Taronga Zoo Sky Safari

Appendix EE
Construction Management Plan
(CMP)
RTS Revision 2

Sky Safari – SSD-46807958
Response to Submissions
Construction Management Plan

Figure 22 Extent of potential works zone on Athol Wharf Road

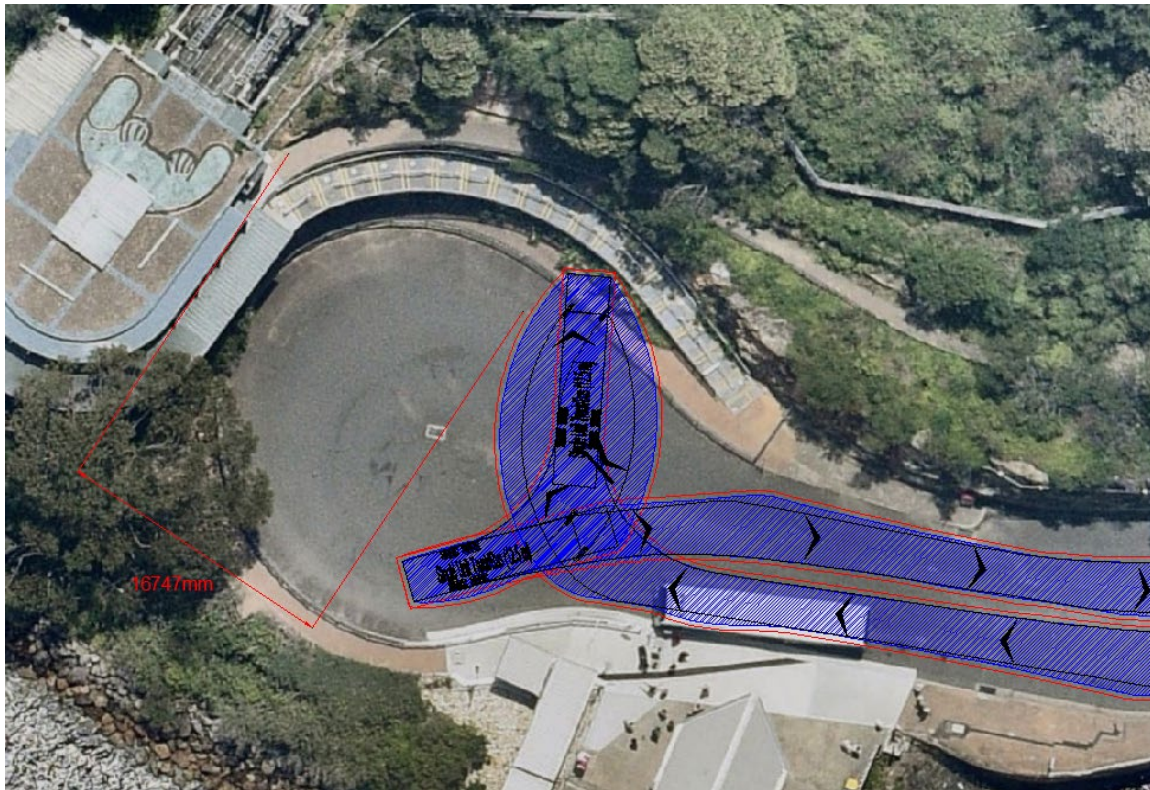
Transport for NSWBased on the documentation provided, the construction methodology for the proposed development, includes using the existing cul-de-sac on Athol Wharf Road adjacent the lower Sky Safari station for construction vehicles only and closing this section of the road to all general traffic including TfNSW run bus services (utilising standard 12.5 metre sized buses from the fleet) with a proposal to replace these existing bus services with minibuses.

TfNSW advises that the Agency does not have any minibuses in the fleet and the cul-de-sac is also used by charter buses that utilise this existing cul-de-sac as a safe U-turn facility on Athol Wharf Road.

As such, as part of any construction zone, TfNSW requires at a minimum that sufficient space is provided in the above cul-de-sac to enable a standard sized bus to always undertake a 3-point turn safely and efficiently under traffic control.

As part of the above requirement for standard sized buses (12.5m) to perform a three-point turn adjacent the construction zone on Athol Wharf Road, the Applicant provided a swept path plan (**TAB B**) that indicates that buses will mount the kerb and hang over the footway adjacent the above-cul-de-sac.

As such, as part of the construction phase of the proposed development, it is likely that the cul-de-sac may require temporary localised widening and adjustment of the kerb to enable a standard sized bus to undertake a three-point turn safely and efficiently under traffic control.

TfNSW advises that Athol Wharf Road is a classified regional road under the care and control of Council as the relevant road authority. As such, any road works required on Athol Wharf Road to facilitate standard sized buses to undertake a three-point turn will need to be designed and constructed to the satisfaction of Council as the relevant road authority.

An updated Traffic Impact Assessment (TIA) has been provided which provides a swept path analysis confirming that the 238 bus service would be maintained during construction, including the existing bus stop on Athol Wharf Road adjacent to the ferry wharf. The works zone on Athol Wharf Road is proposed to be configured to allow a standard 12.5m long bus to undertake a three-point turn to maintain this existing public transport service. This will be enabled by the temporary demolition of a small section of the existing kerb and footpath which would be subject to a local development application with Council. The applicant attended a pre-lodgement meeting with Mosman Council on 17 February 2025 to discuss this application and no concerns were raised by Council.
